**Re: D&B LIMITED TRUST LLC - A.Varela request for Alternative Landscaping plan & Pervious material credit**

Drawing file: 2-24-2025 / -AC3 PAVING PLAN.pdf

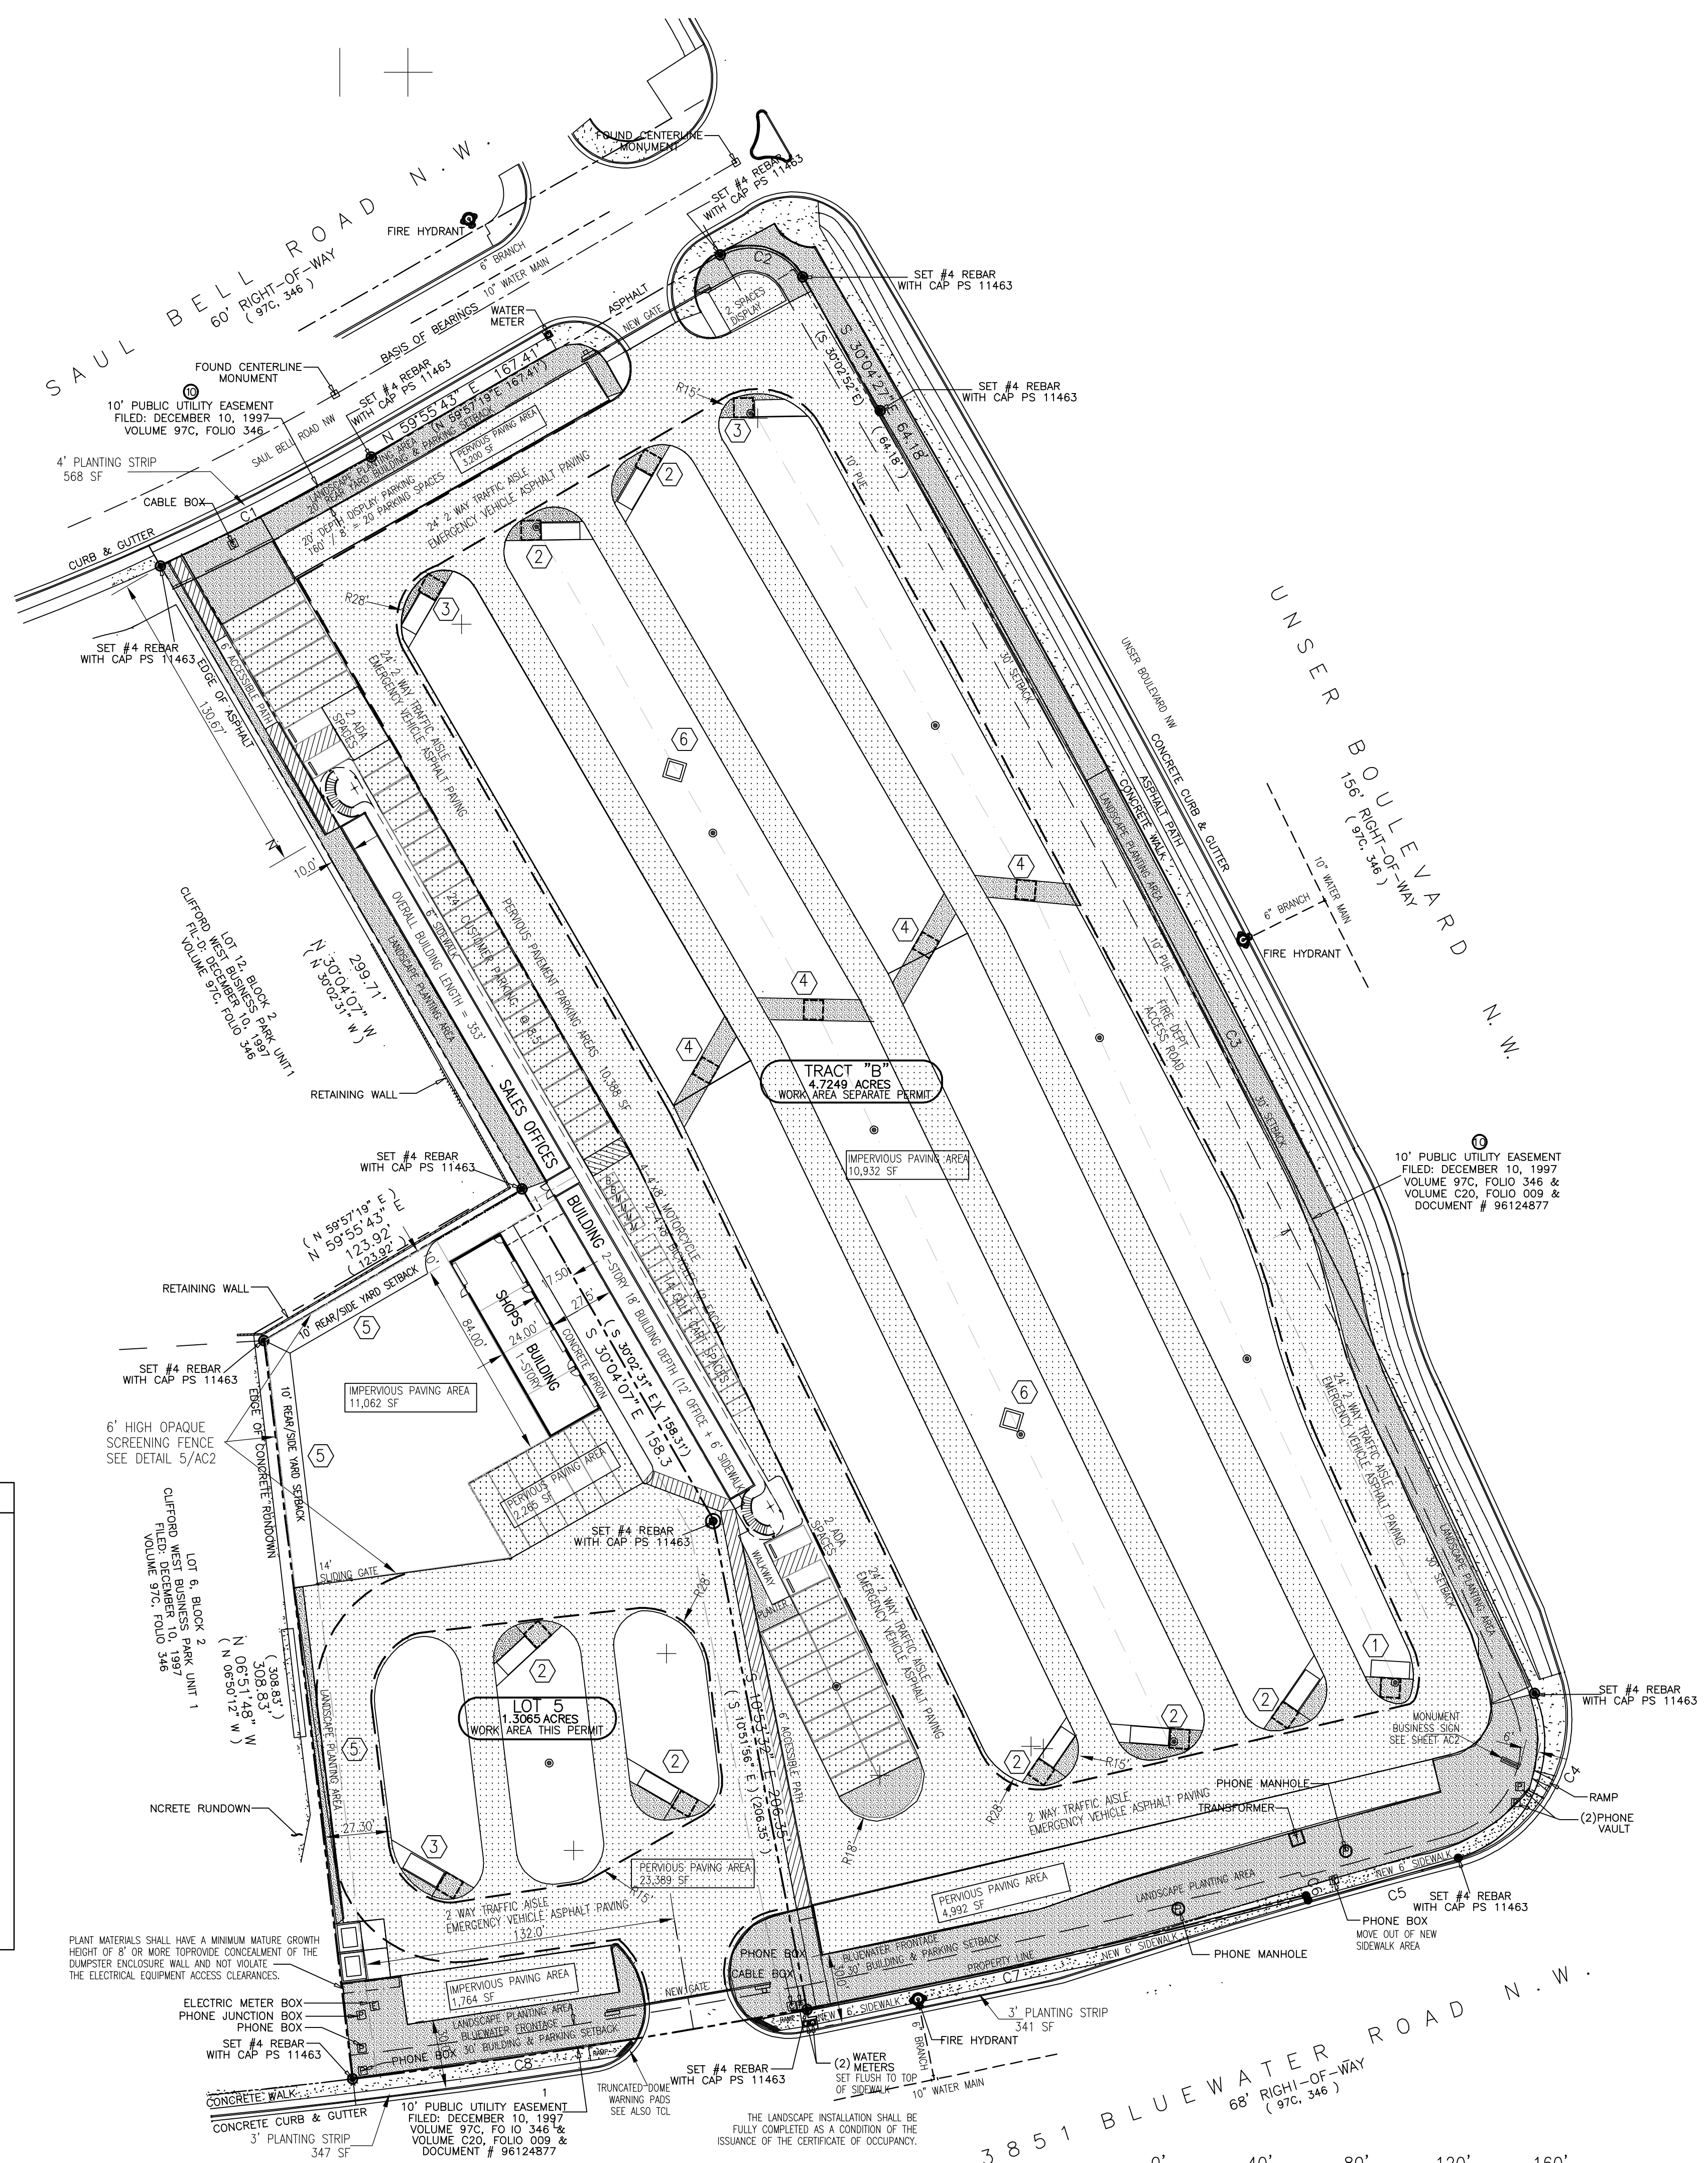
We basically need both the Fire Department and City Engineer's office approve the proposed surface. We need to ensure that the surface is drivable and permeable as well.

1. Per the City Engineer: wherever the permeable surface will be used by Fire Trucks, then it has to be a *drivable* surface. Therefore, the AFR engineer must propose a drivable surface (like permeable pavement) for approval by the City Engineer.
2. The required landscaping is typically for the on-site landscaping, but the City will provide credit for the areas being landscaped within the right-of-way due to the nature of the site.

1. The number of proposed trees in the most recently submitted Alternative Landscaping Plan is acceptable and must be provided for the site: **91 trees**
2. A reduction to 30,966 SF of landscaped area is approved on the following conditions:
  1. All parking areas and vehicle circulation areas and drive aisles must be permeable surfaces
  2. The material for the permeable surfaces must be approved by the City Engineer or his designee

We can move forward with the understanding that a permeable surface will have to be approved and placed on site prior to Certification of Occupancy. It will be the responsibility of the your **civil engineer** to provide us with the proposed surface material ASAP.
